Please ask for: Katherine Pannifer
Your reference: PPA517432431
Our reference: DC/23/02408
E-mail: heritage@baberghmidsuffolk.gov.uk
Date: 1st June 2023

Proposal: Heritage Pre Application. Meeting on site & a written response - House holder extension (part of pre app DC/23/01984)

Location: Granary Cottage, Upper Langdales Farmhouse, Mill Lane, Earl Stonham Stowmarket Suffolk

Job Reference Drawing no. Revision  
**21-242-203**

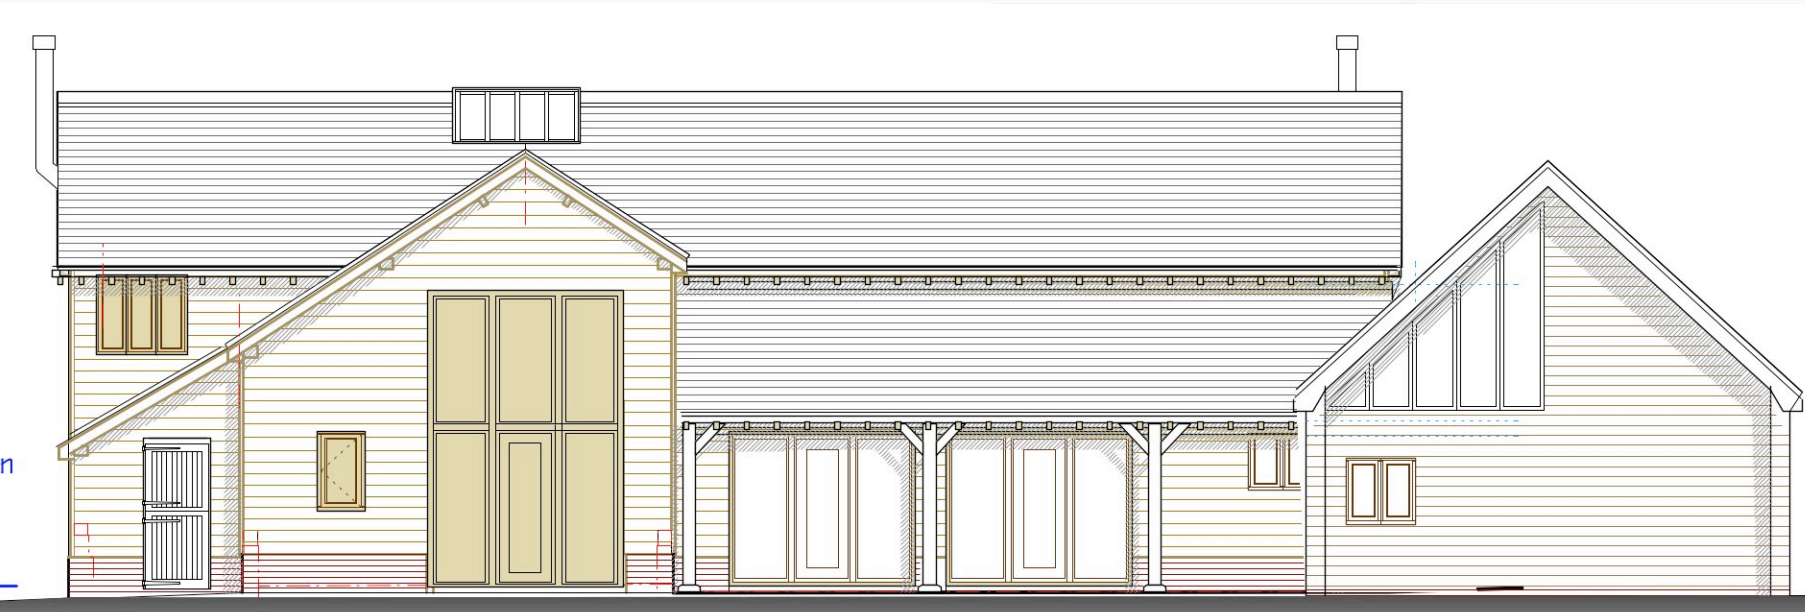
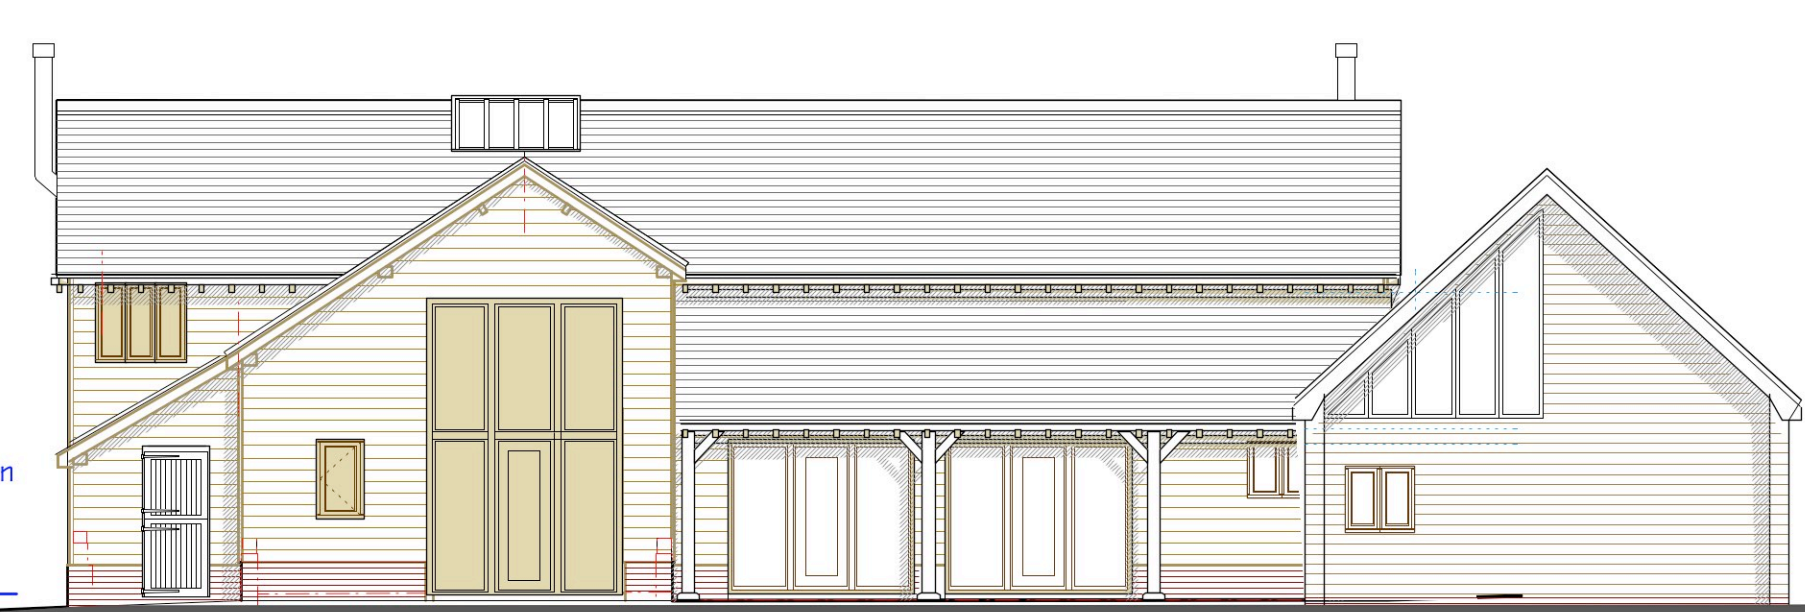
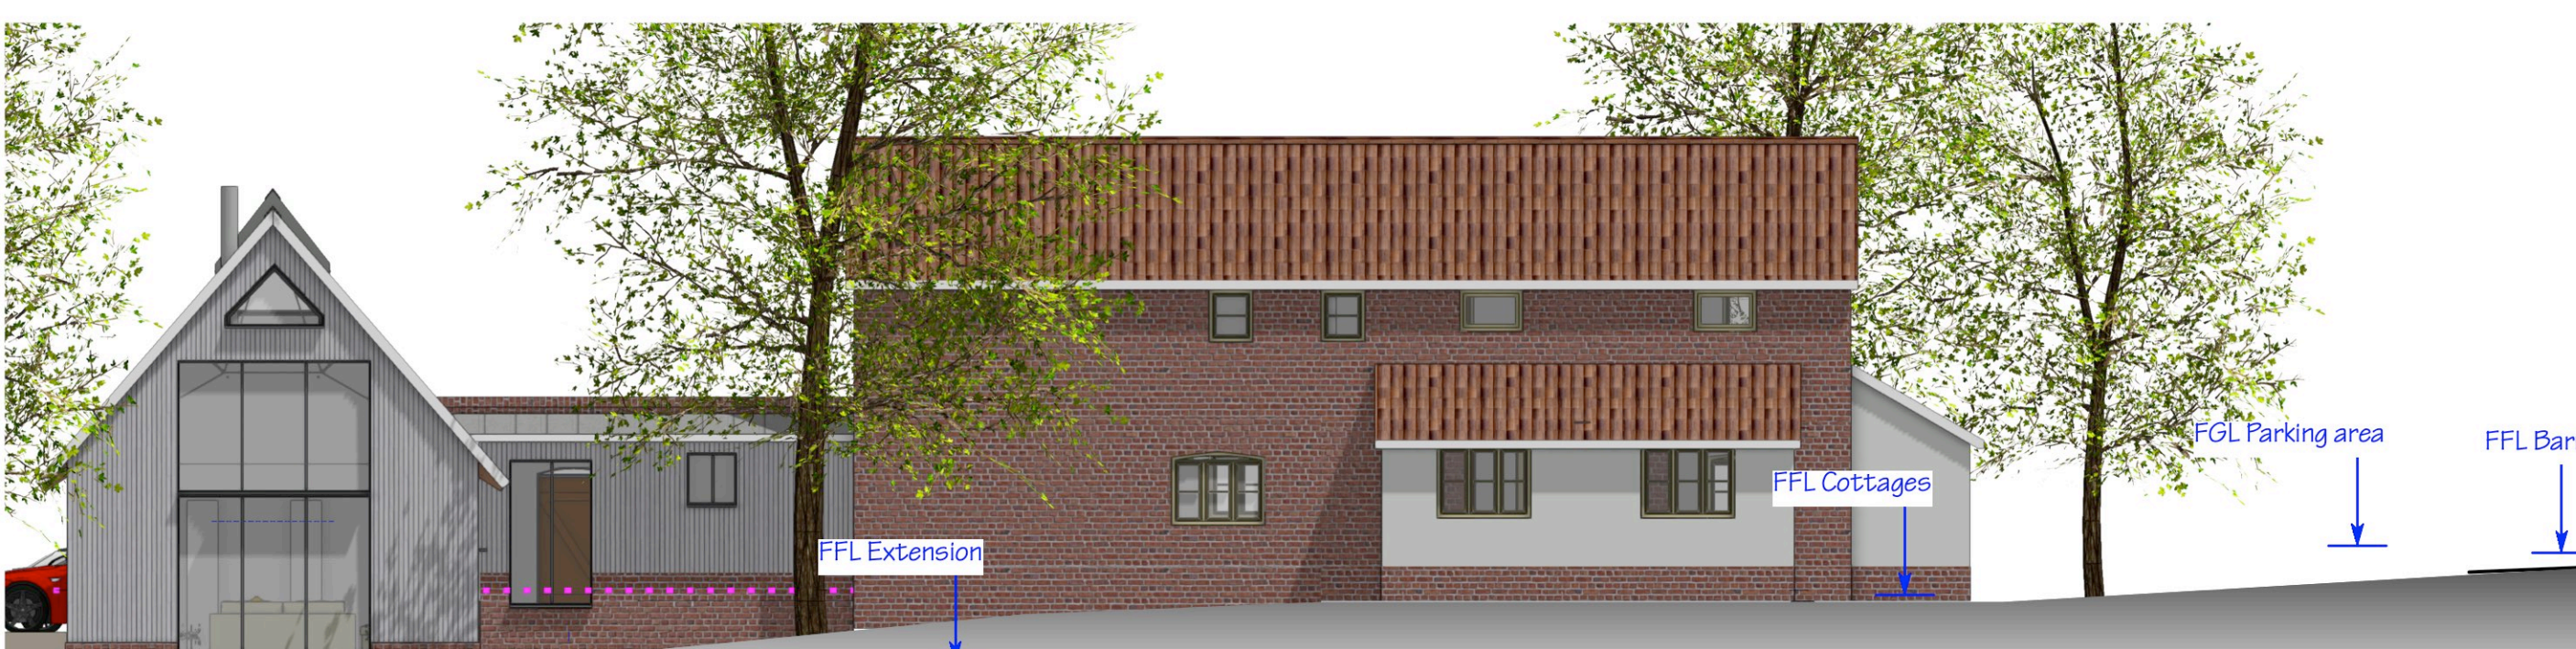
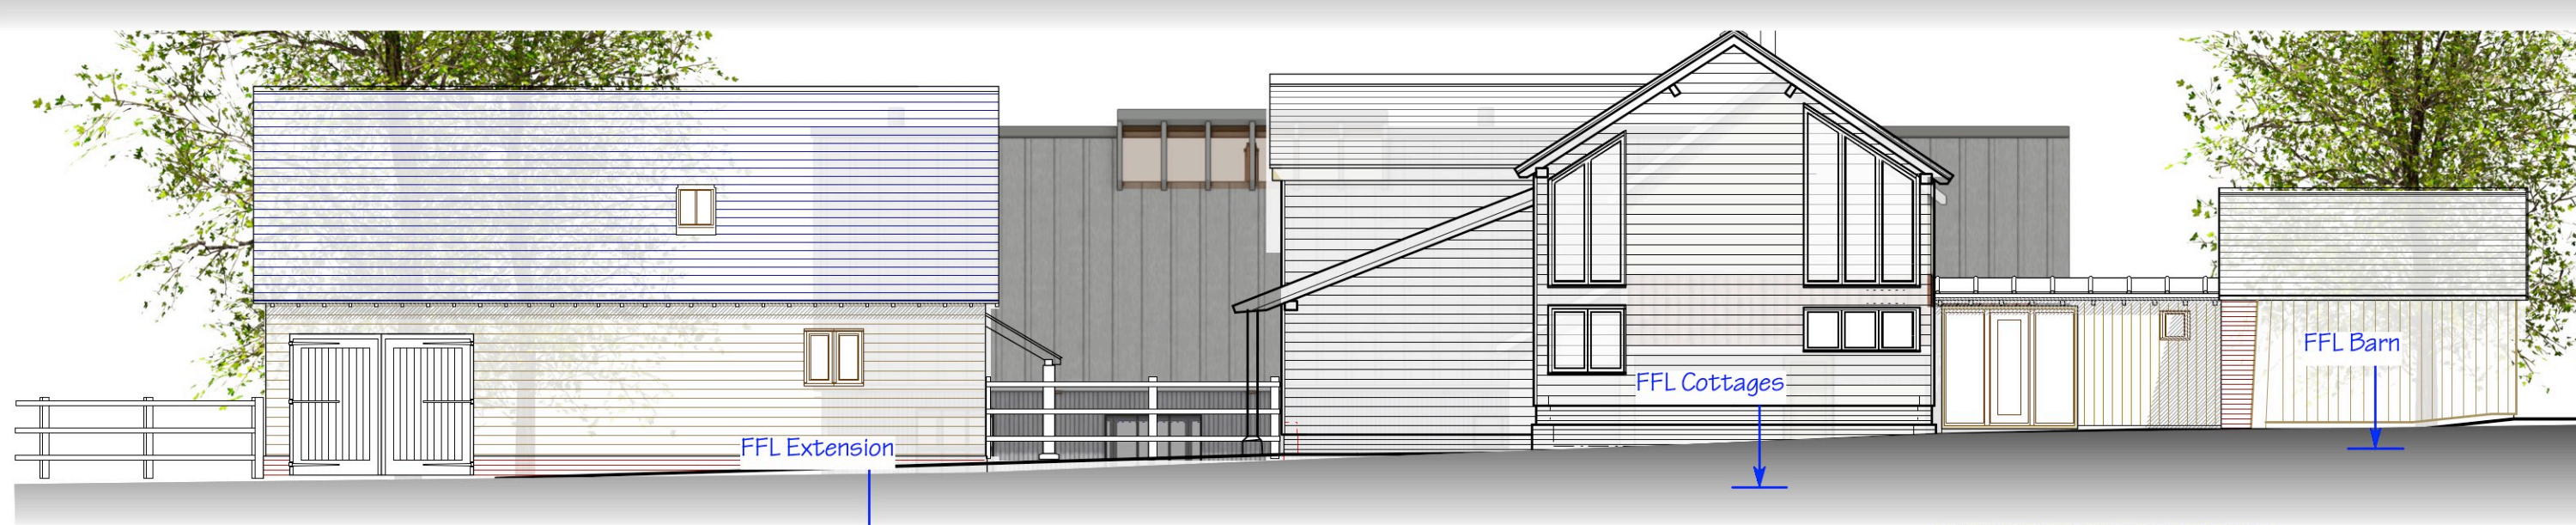
The revised plans submitted as part of this pre-application enquiry have reduced the overall length of the 'link detached' style extension, allowing for the gable end to be further set back away from the former farmhouse. Also discussed on site was the topography of the land which the extension would occupy, which lowers to the south east away from Granary Cottage and is lower than Dogwood House. The possibility of reducing the ground to this lower level prior to the construction of the extension was discussed and was considered an appropriate way to reduce the overall finish height of the proposed extension. A reduction in the proposed ridge height would also help to reduce the dominance of the proposed extension.

Whilst the proposed replacement extension would still amount to a roughly 40% increase in footprint to the structures to be demolished, it is considered that by reducing the overall dominance of the proposed extension can by lowering the ground level and/or ridge height then the extension would not harm the hierarchy of structures within the setting of Dogwood House. This is also subject to appropriate material detailing, which may be appropriate to secure via conditions on any approval.

In summary, the principle of the proposed demolition of existing structures and erection of a new extension is considered appropriate subject to further details. The reduction of the scale of extension proposed has helped to reduce its dominance within the former farmstead group, and should be further reduced by a reduction in height to visually demonstrate its subservience.
